STORMWATER MANAGEMENT PLAN

Commercial & Maple Street
Mixed Use Development
Portland, ME

Woodard & Curran Comments dated 12/12/12

STORMWATER PLANTER PLAN
NOT TO SCALE

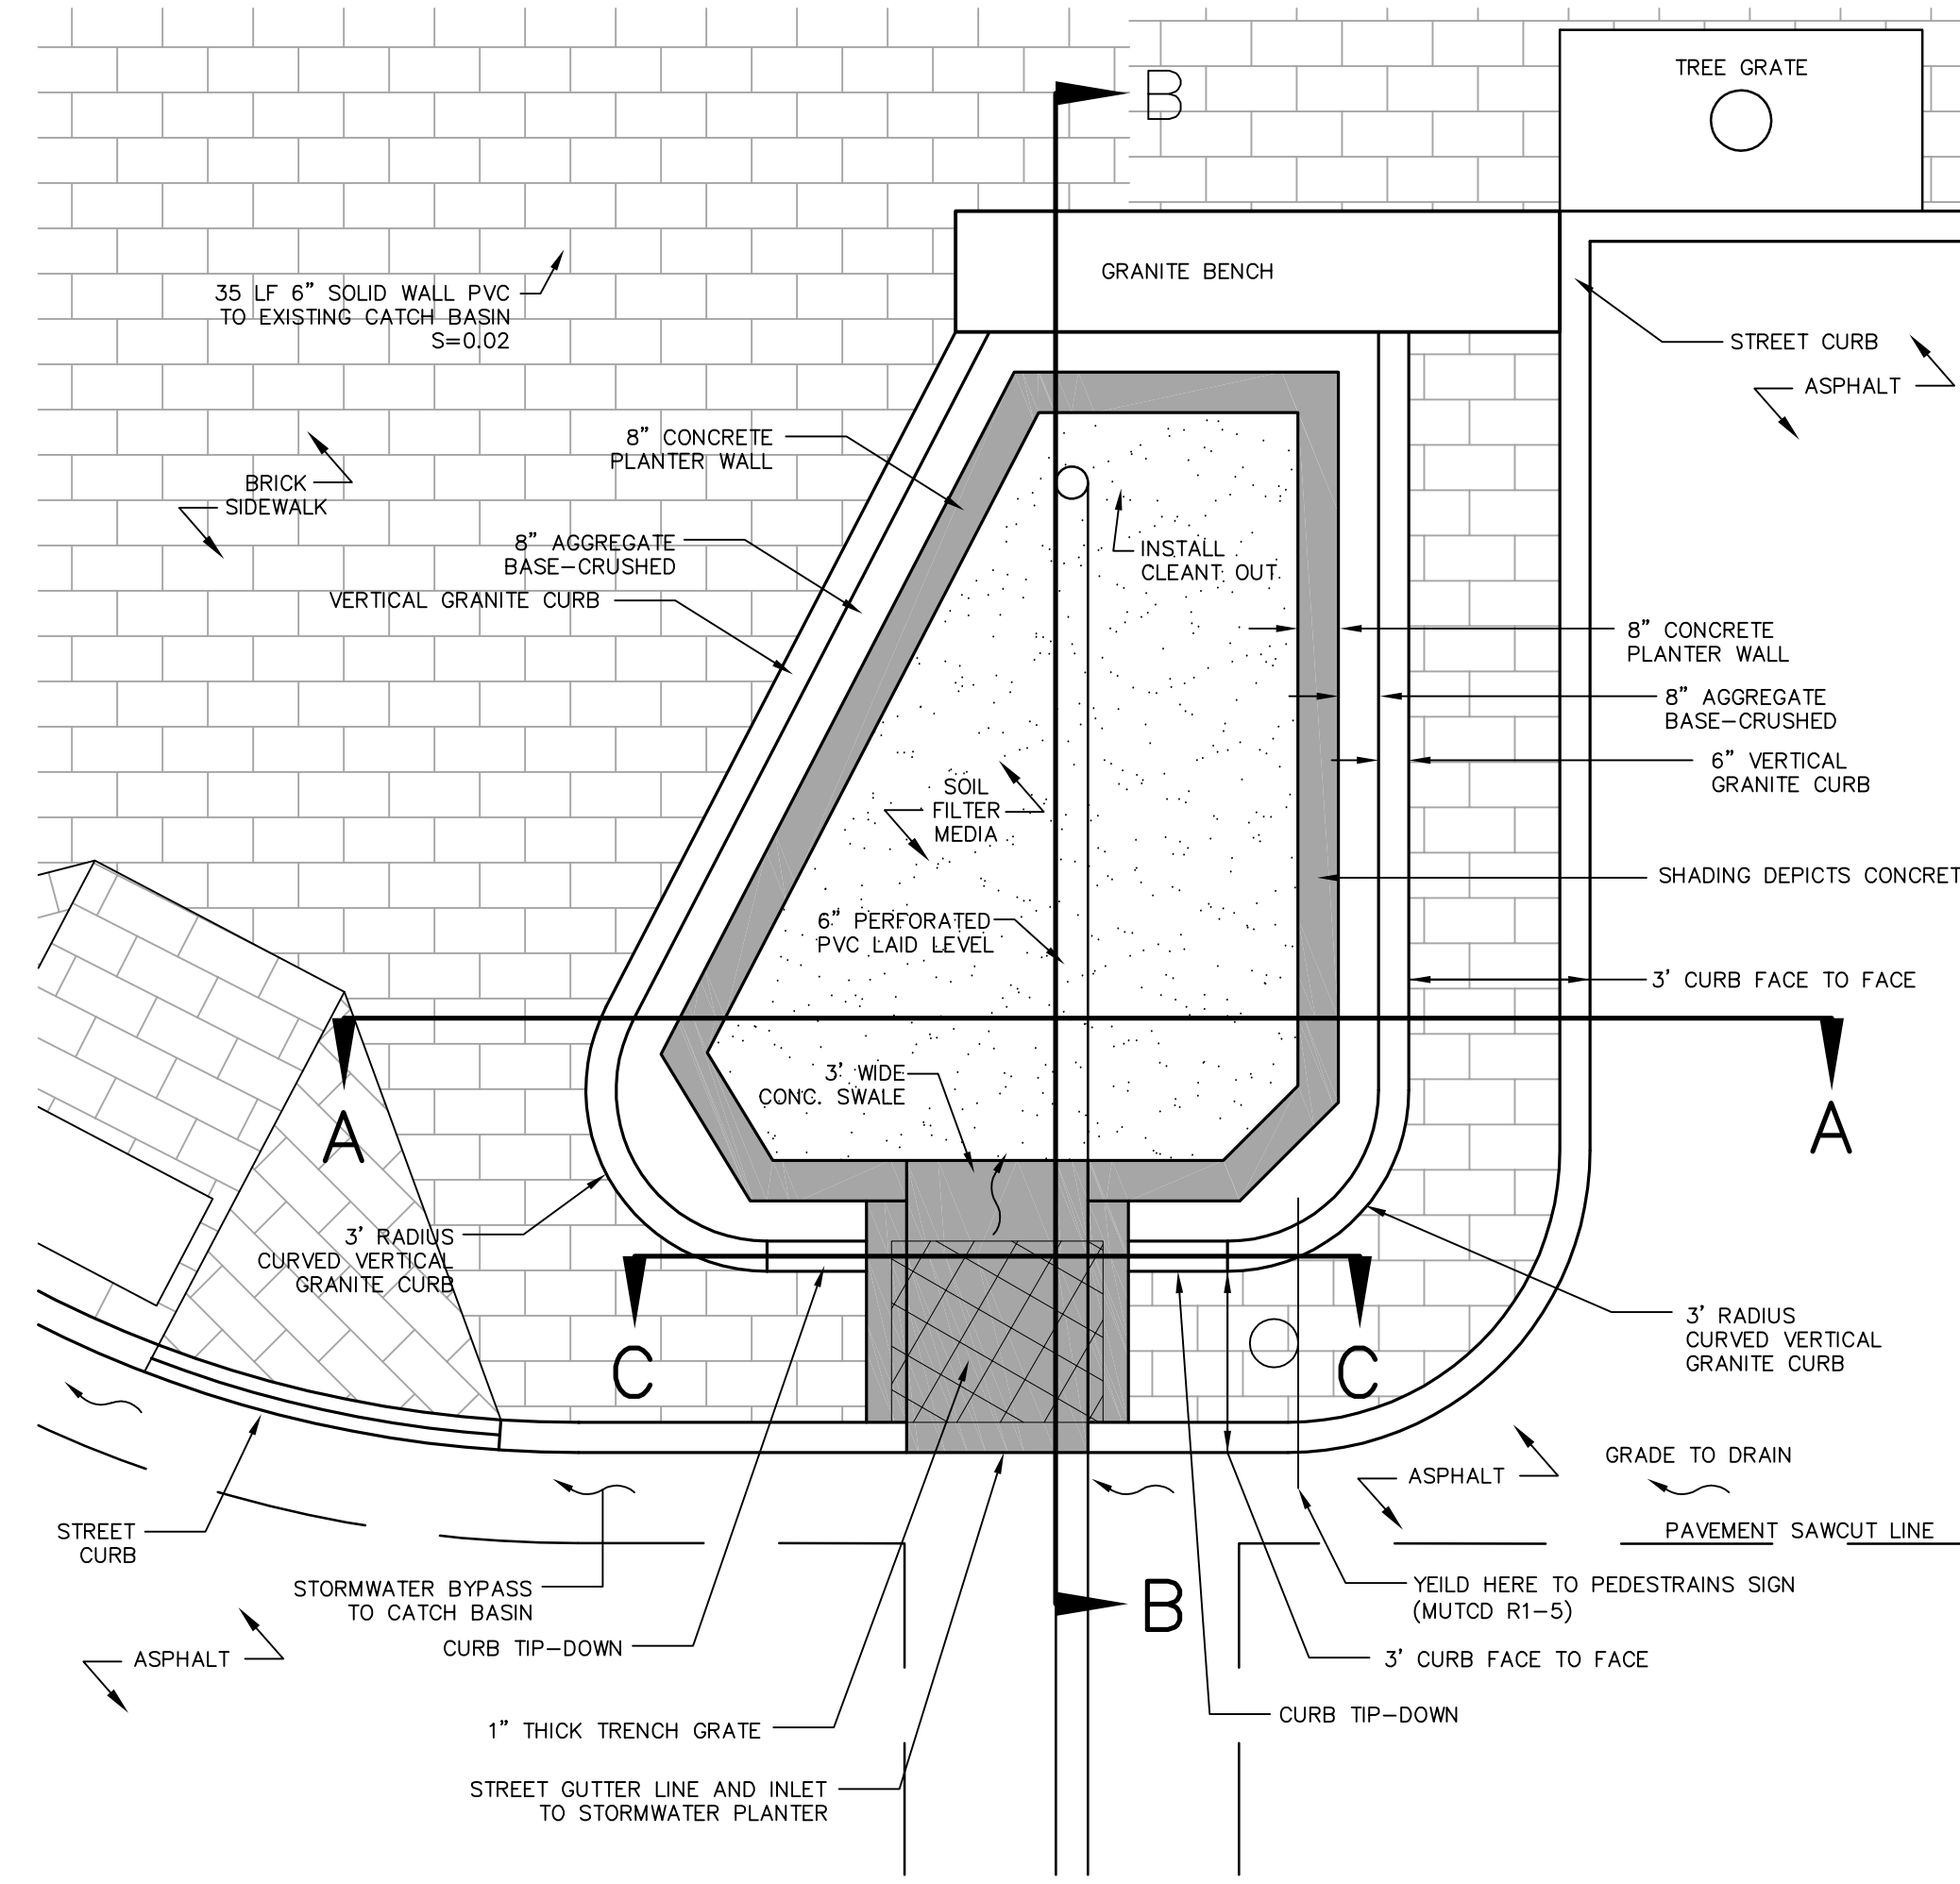
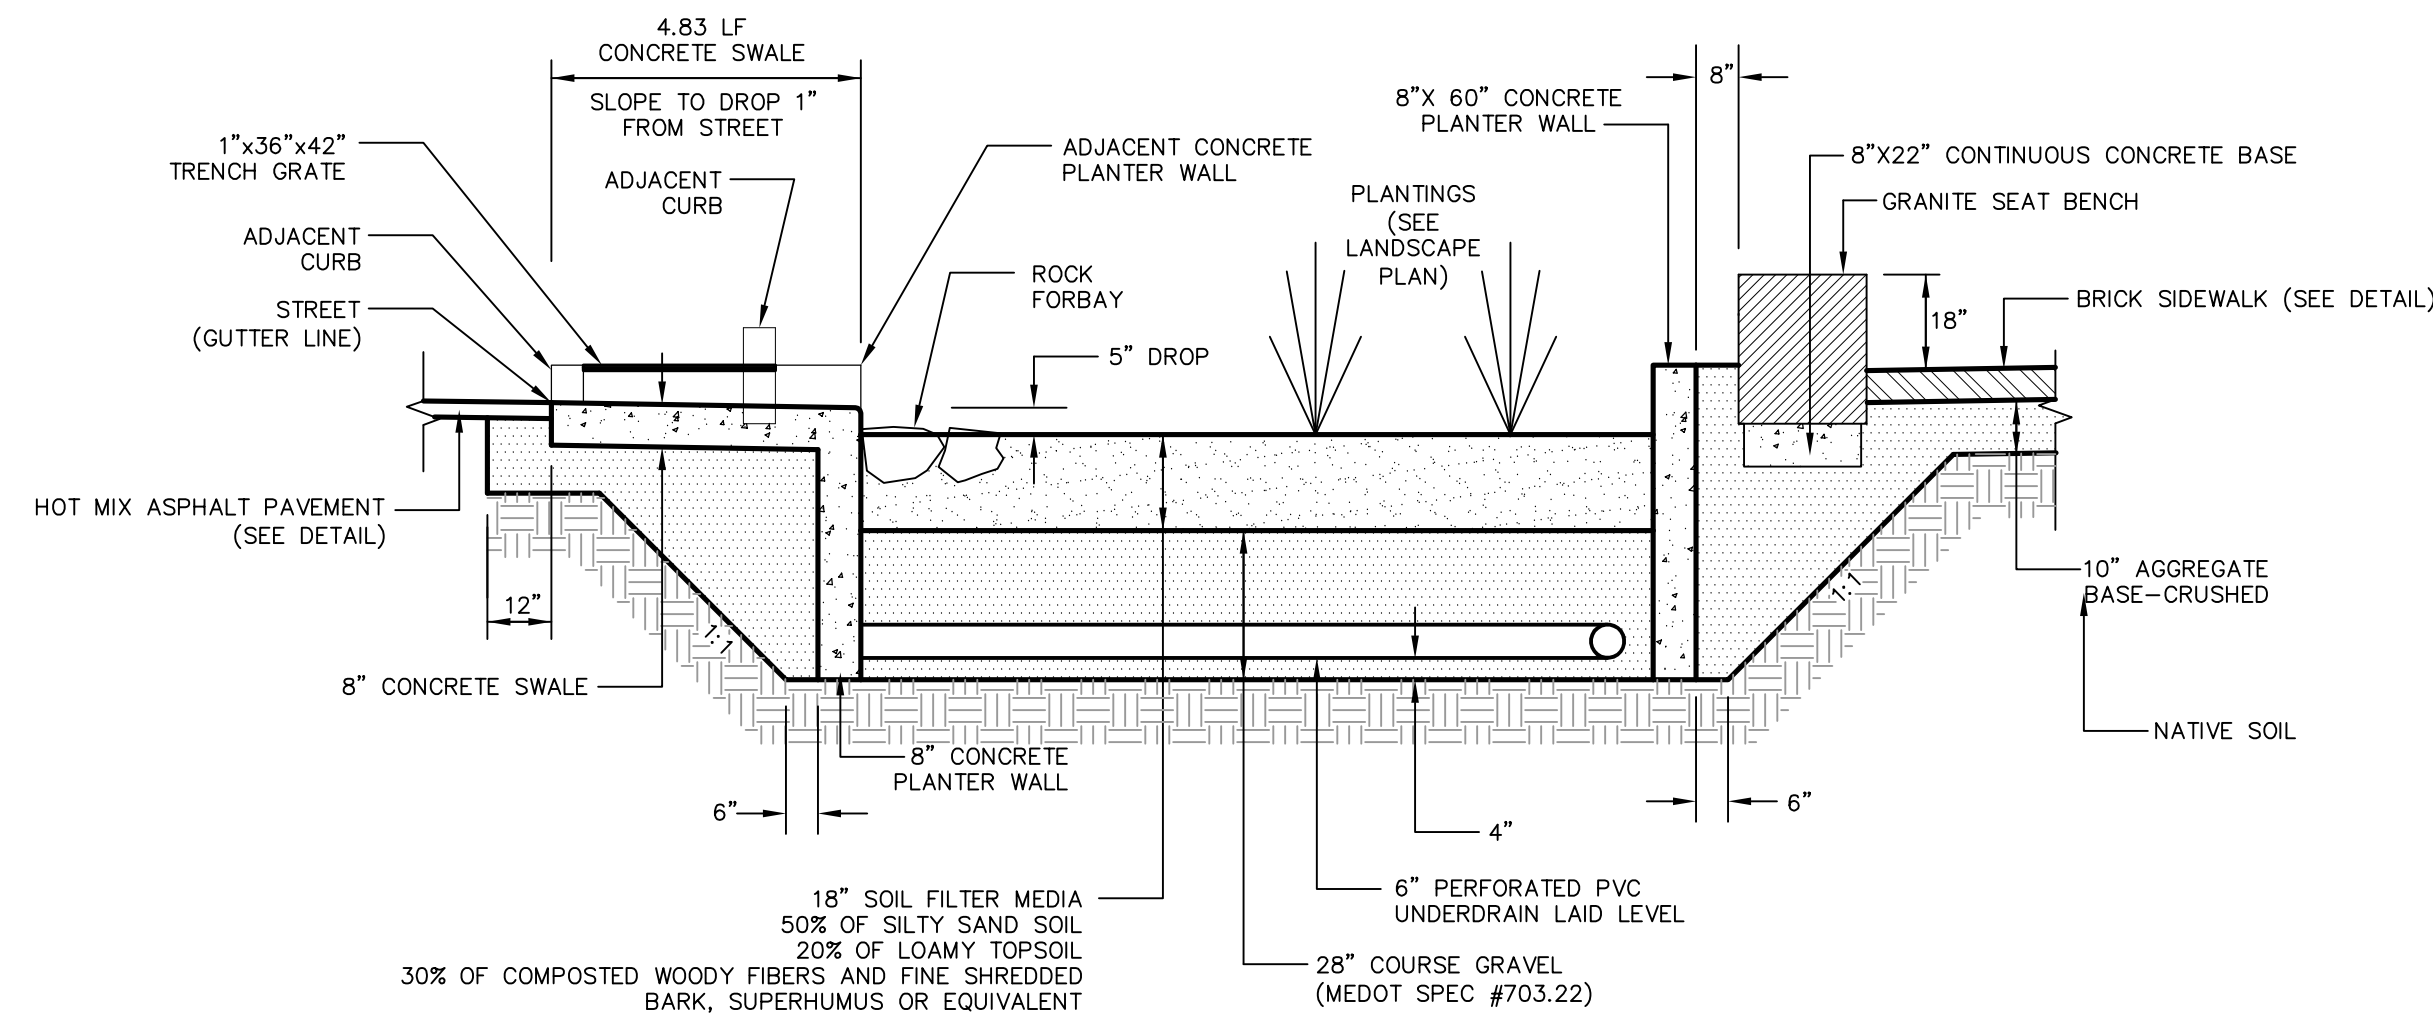
1. The Applicant has identified a "green area stormwater treatment" system Within a bump-out on Commercial Street to provide water quality treatment for approximately 6,810 sq; ft of sidewalk,, roadway, and on-street parking area. This system would provide treatment for an area in excess of the proposed new impervious area resulting from the project (2,513 sq ft). Pending review of the design details associated with this system, the proposal provides an acceptable means of meeting the City of Portland's water quality treatment requirements. We understand that additional information and plan revisions are forthcoming, and we anticipate reviewing engineering calculations for the treatment system, specifically the ability to provide water quality treatment for the 1", 24-hour storm event. In addition, we will review design details and modifications to the Inspection and Maintenance Plan. The system is proposed within the municipal Right-of-Way, so the Applicant will need to execute an agreement with the City of Portland specific to inspection and maintenance responsibilities.

A green area stormwater treatment area is now being proposed within the bump out at the Commercial Street and Maple Street intersection. Please see the attached Post-Development Drainage Plan showing the impervious area (Subcatchment 21) to be treated. There will be a total of 3,950 sq.ft. of impervious area directed to the stormwater planter. The planter cross-section will be revised as per the attached plan view and details. The revised planter will have 18 inches of soil media and a 6 inch perforated PVC underdrain, within 24 inches of crushed stone. This will allow the volume of runoff created by the 1", 24-hour storm event to be treated. Please see the attached HydroCAD printout that demonstrates the planter's capacity.
